H22-0566-26

FORMAL OBJECTION TO PLANNING APPLICATION

Re: Planning Application – H22-0566-26

Proposed Free Range Egg Production Unit, Delgate Bank, Weston

Drawing
Elevations and Plan View A1

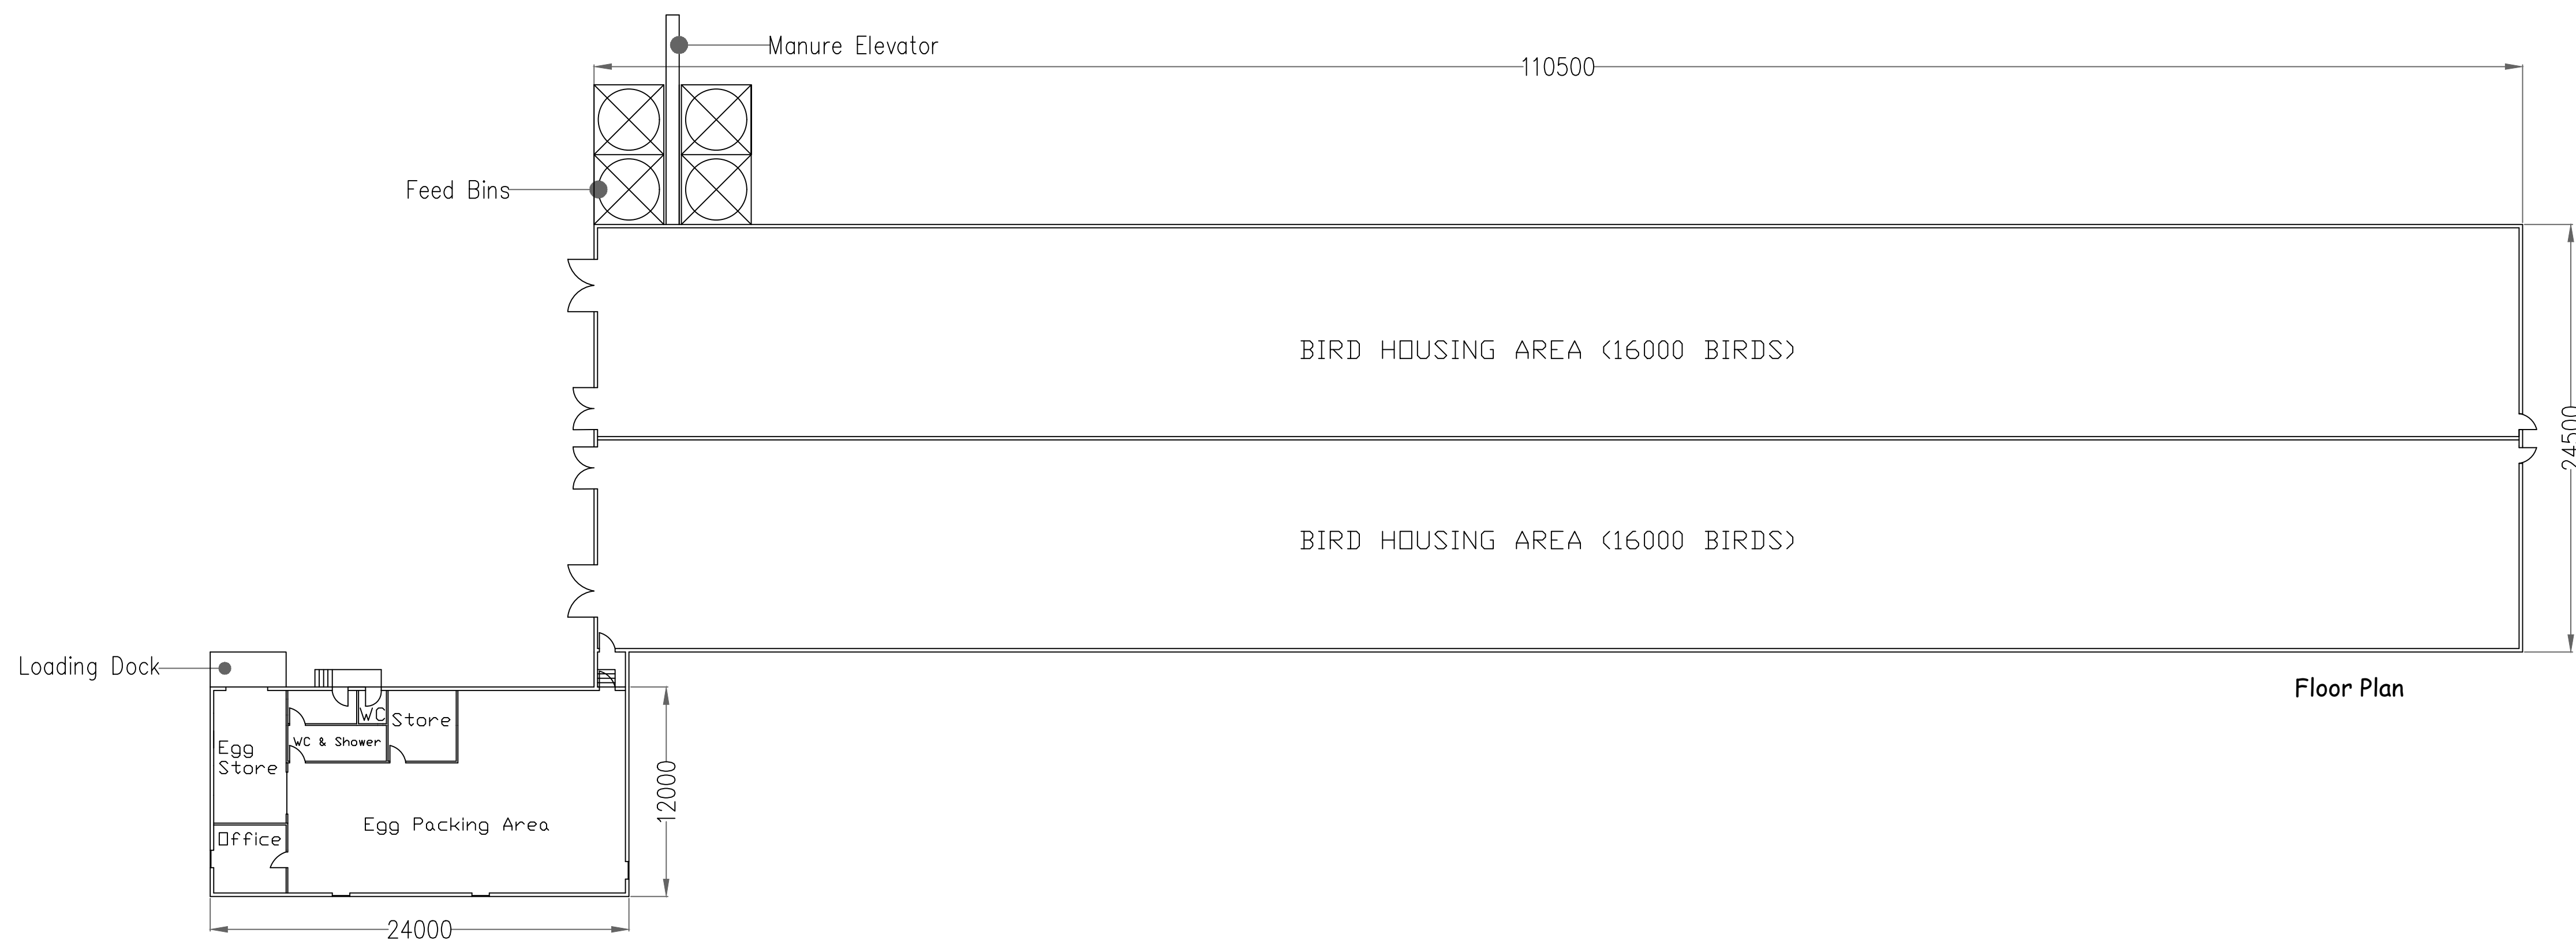
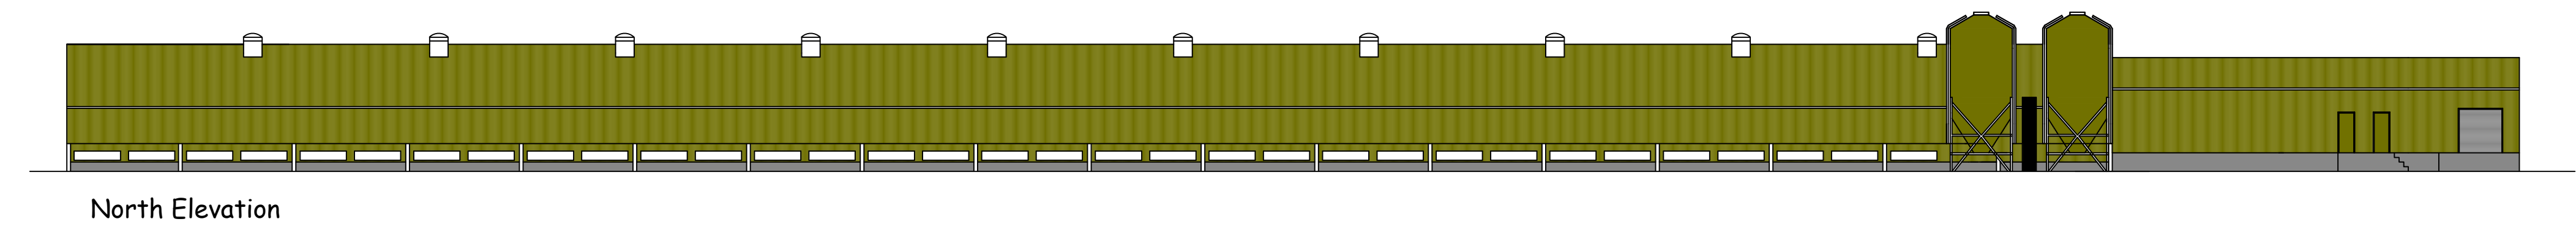
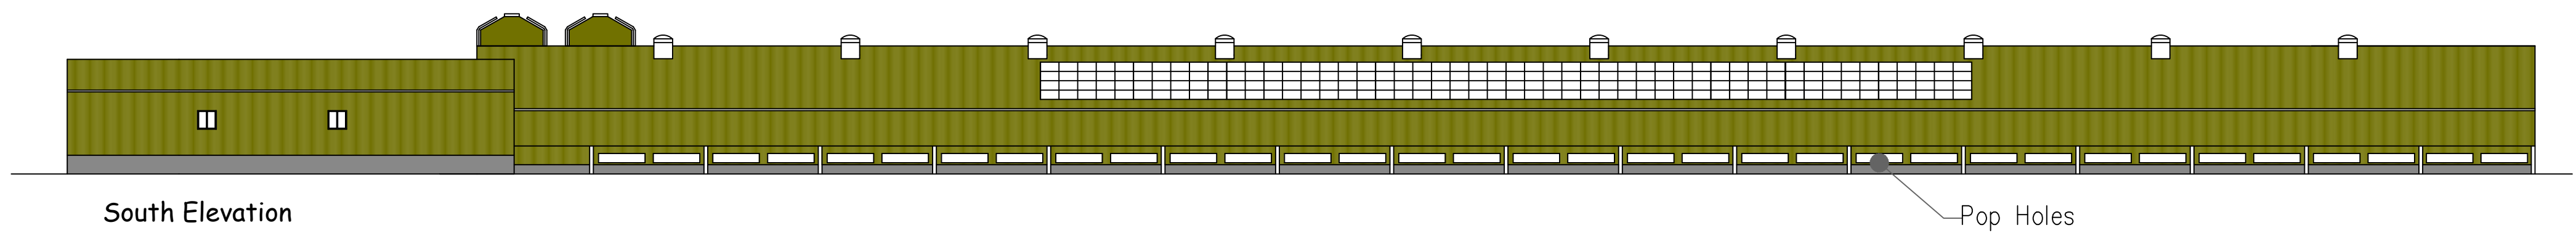
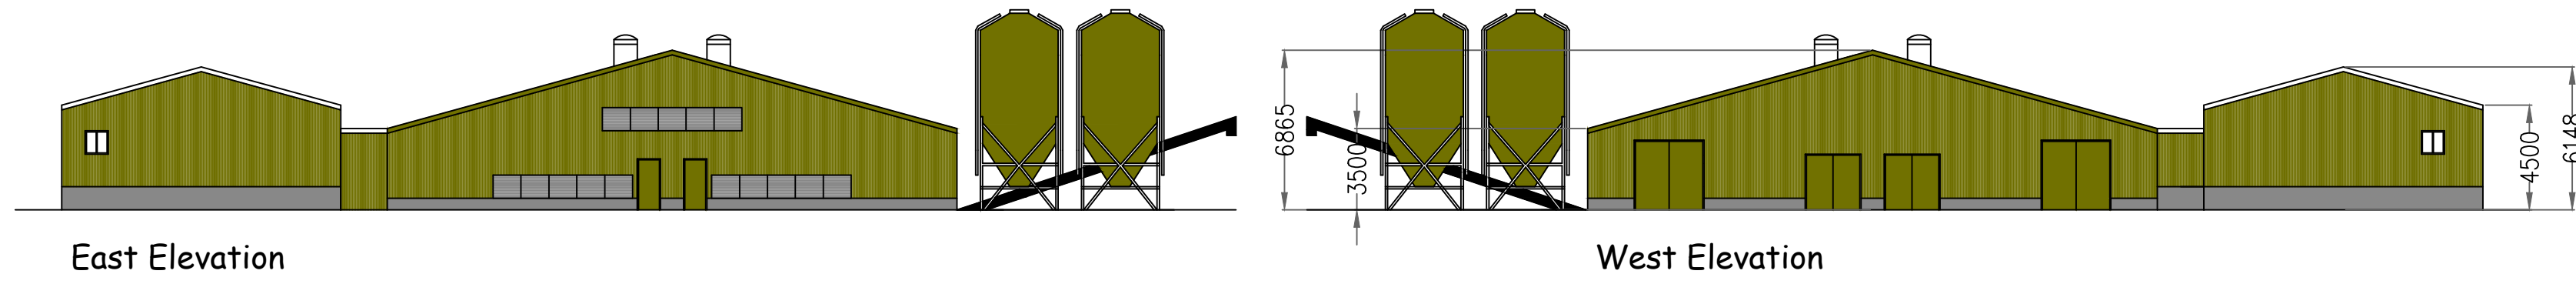
The proposed building measures approximately 110.5 metres long, 24.5 metres wide and approximately 8.8 metres high to the ridge, creating a building of almost **2,700m²**.

The Landscape and Visual Appraisal concludes that impacts will be minor.

The Parish Council considers that conclusion to be unsupported.

The building:

- occupies an isolated position within an open Fenland landscape;

- will be visible over considerable distances;
- is substantially larger than surrounding agricultural buildings;
- relies upon landscaping that will take many years to become effective;
- sits alongside existing and proposed electricity transmission infrastructure.

Proposed Access Design - Scale 1 : 250

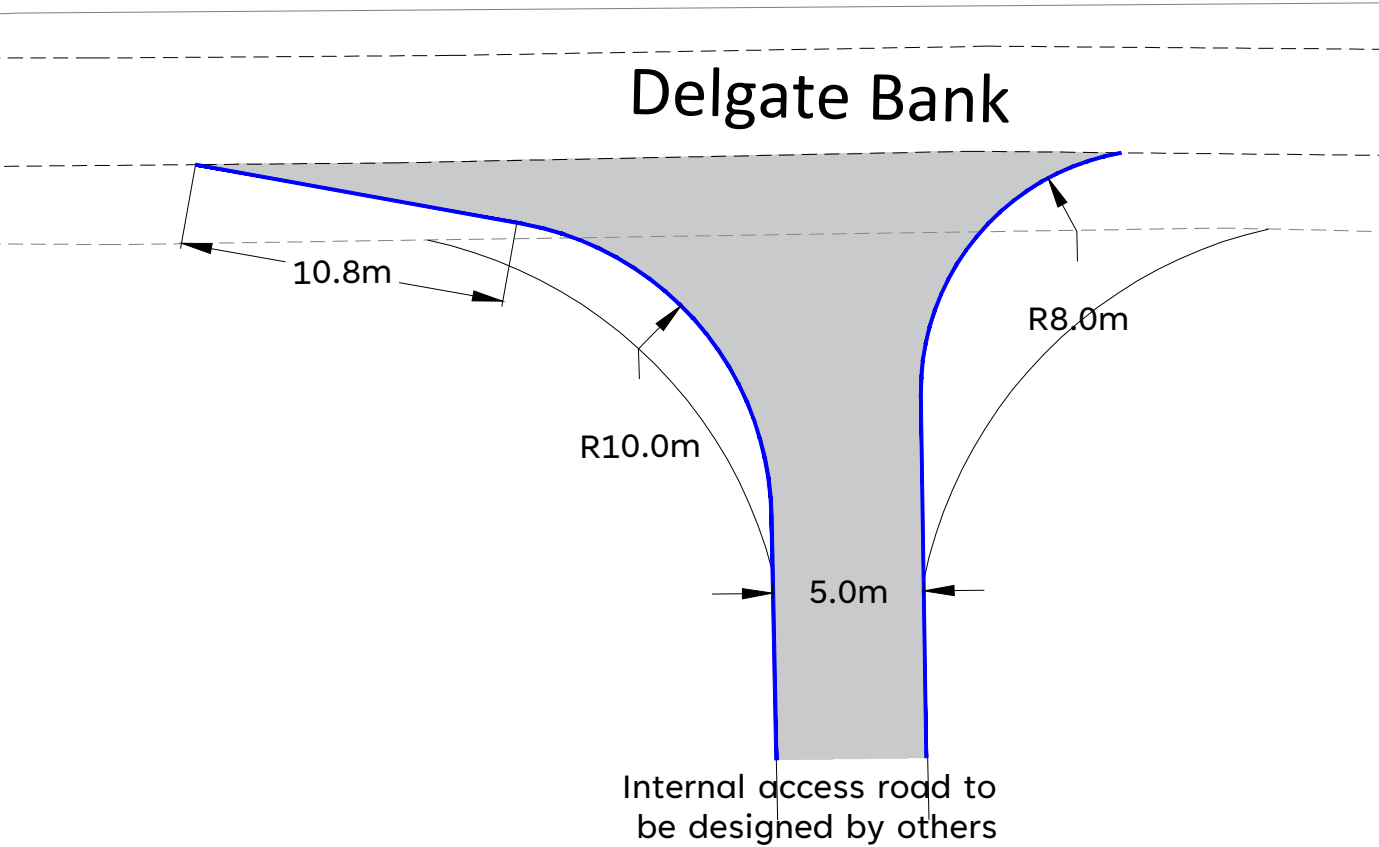
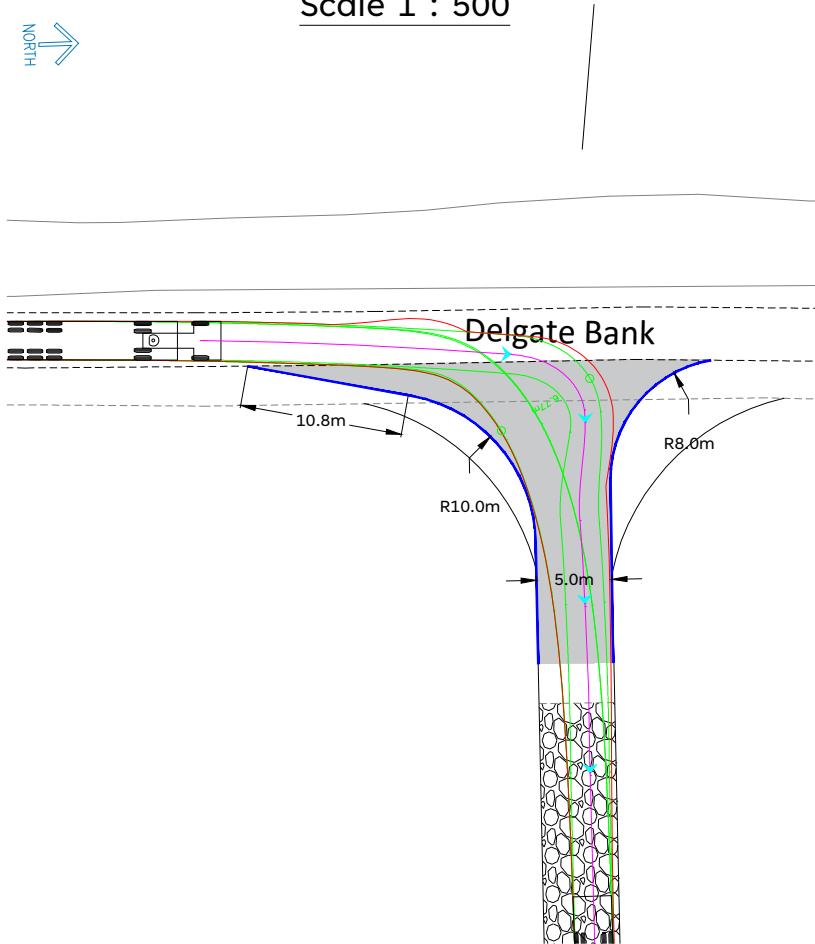
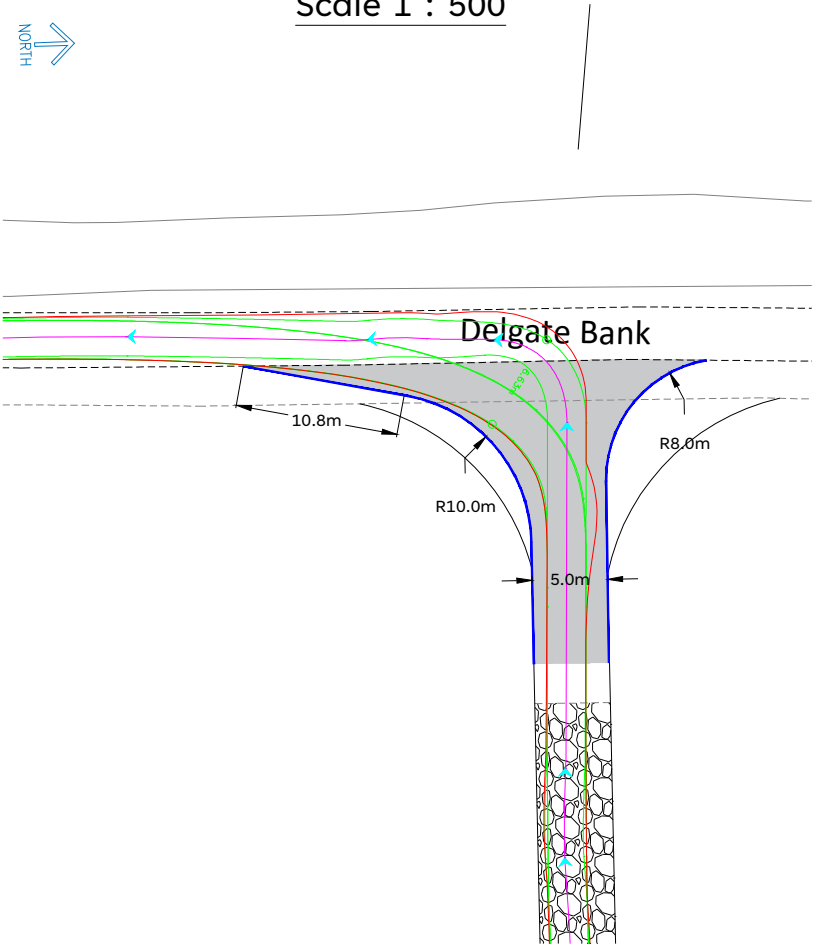
Delgate Bank is approximately 3.2 metres wide in places and functions as a single-track road not 3.7 metres as stated in the application. It is adjacent to the Delgate Drain with no identified passing places.

The Transport Statement does not adequately assess:

- opposing HGV movements;
- agricultural machinery;
- reversing distances;
- passing opportunities;
- restrictions caused by Delgate Drain and mature hedgerows.

Appendix 3 – Collision Plot

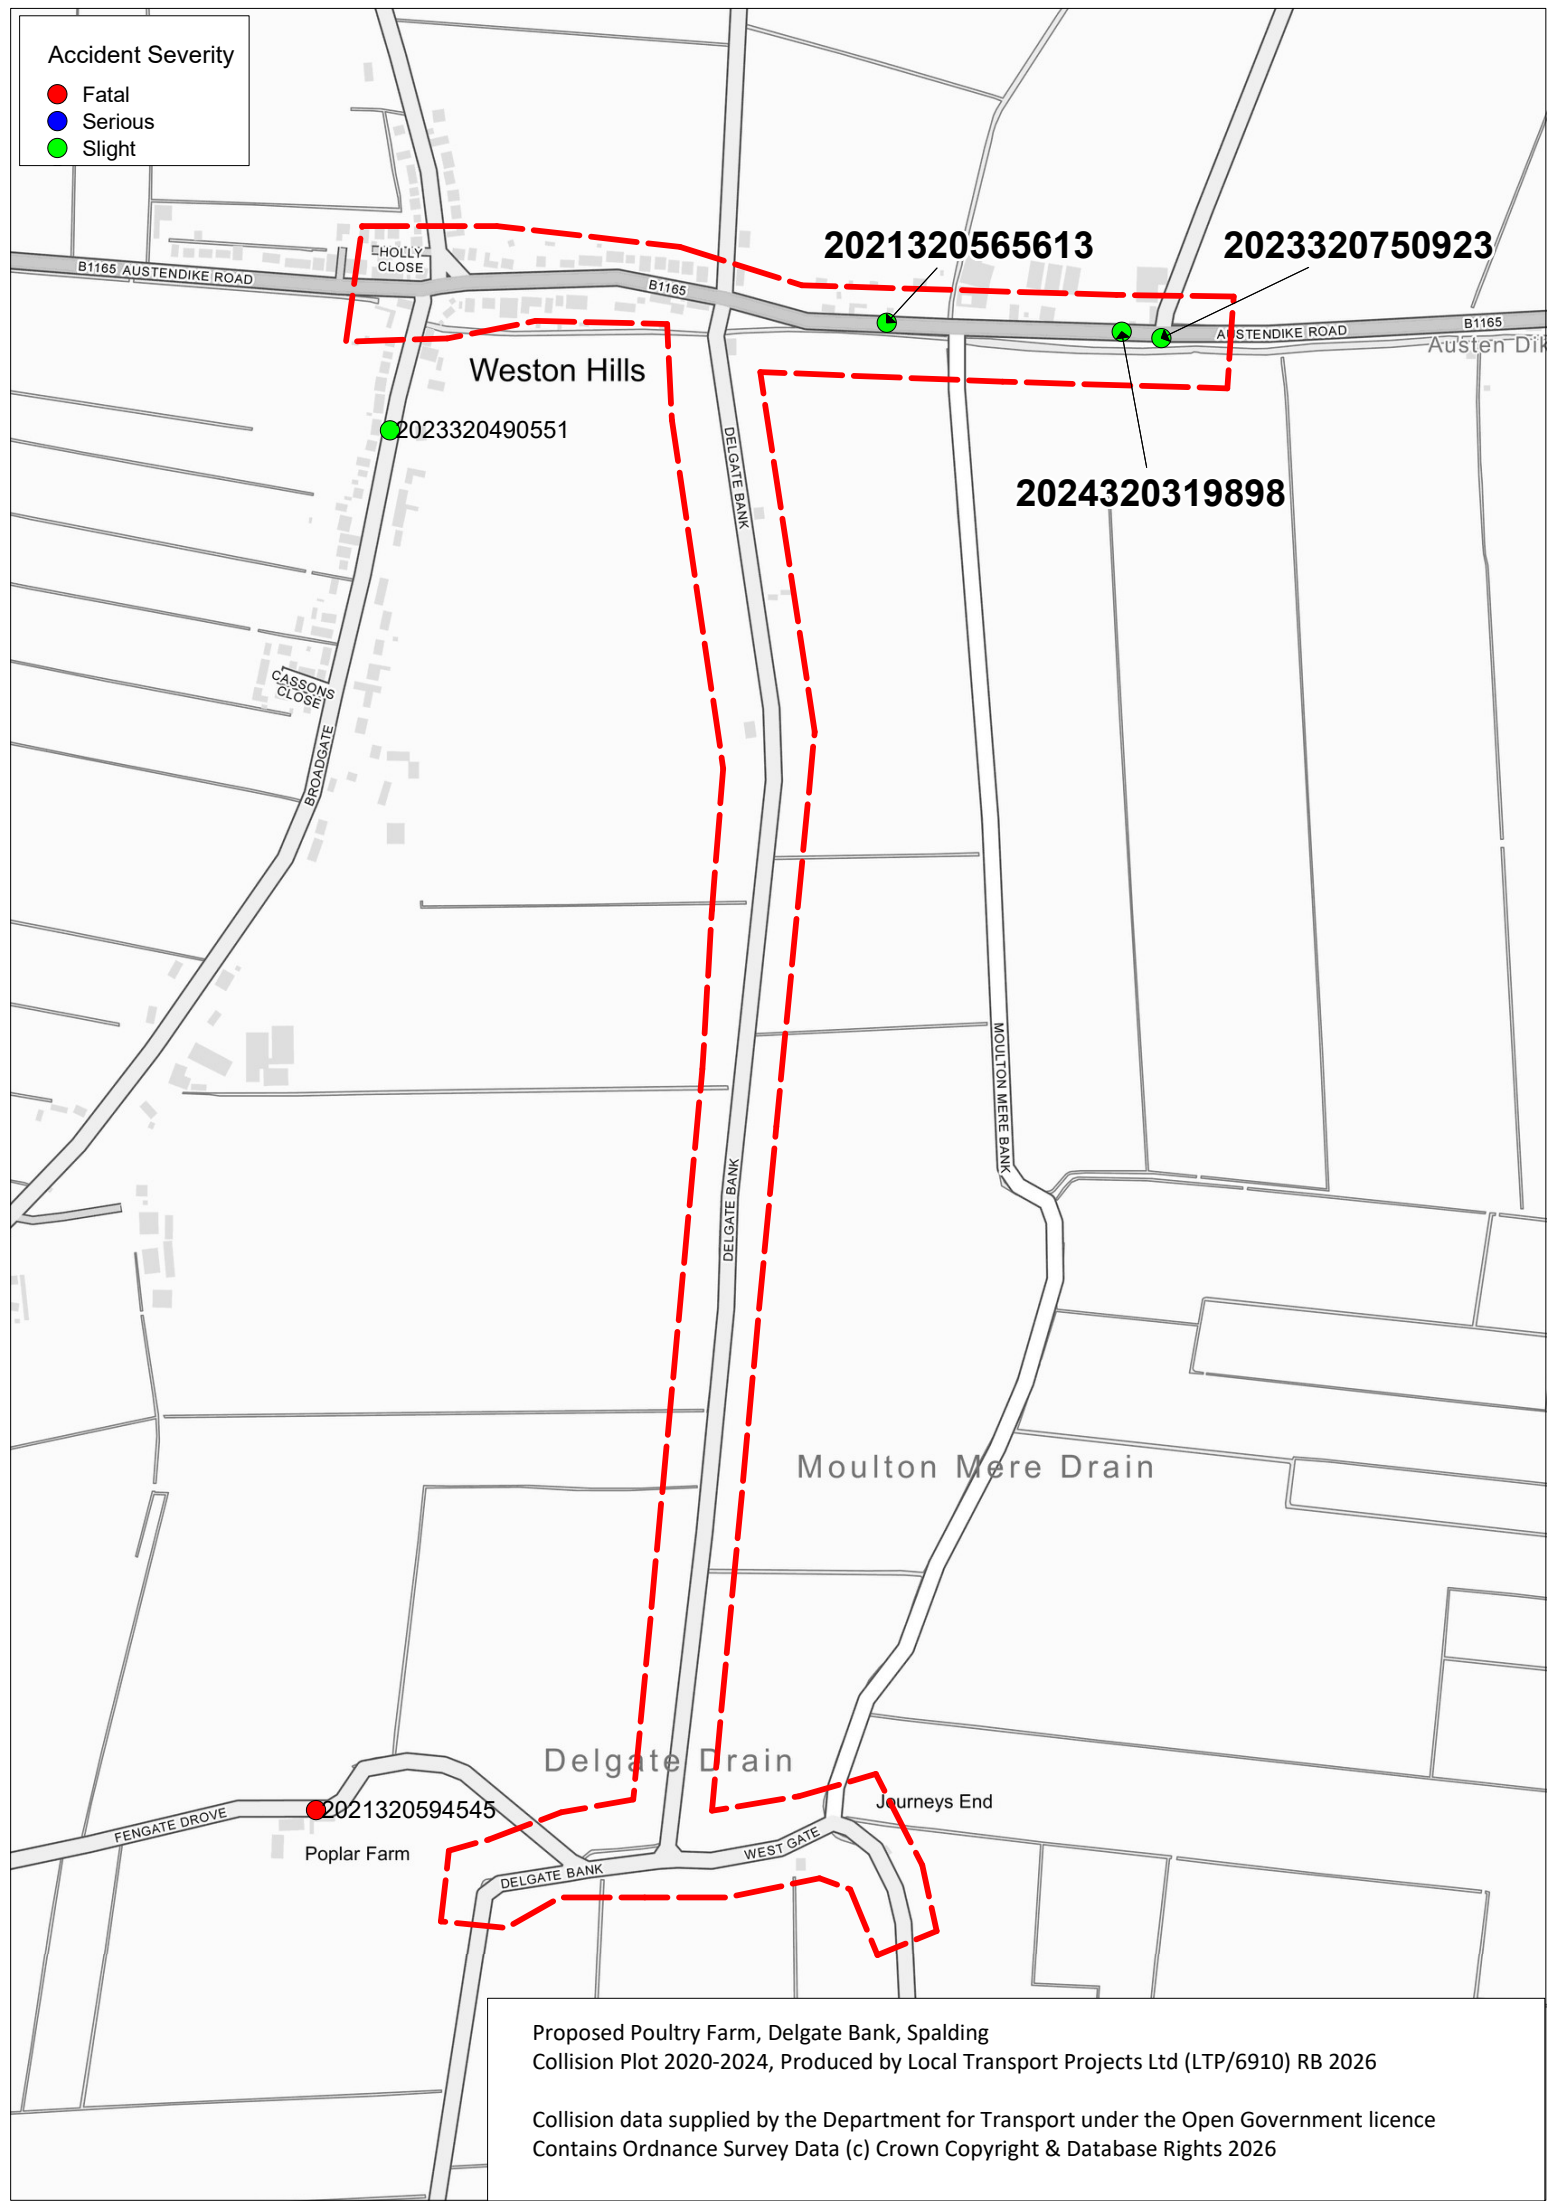
The collision assessment appears incomplete.

Known police-attended accidents are omitted, including:

- Delgate Crossroads – 27 October 2024 (three vehicles);
- Austendyke Road – 14 December 2024 (two vehicles).

If the collision dataset is incomplete, the conclusions regarding highway safety are unreliable nor do they reflect the roads identified as the main route i.e. Moulton Chapel Rd and Fengate Drove/Delgate Bank and Westgate. This route is marked at the Fengate Drove entrance as Unsuitable for HGV's.
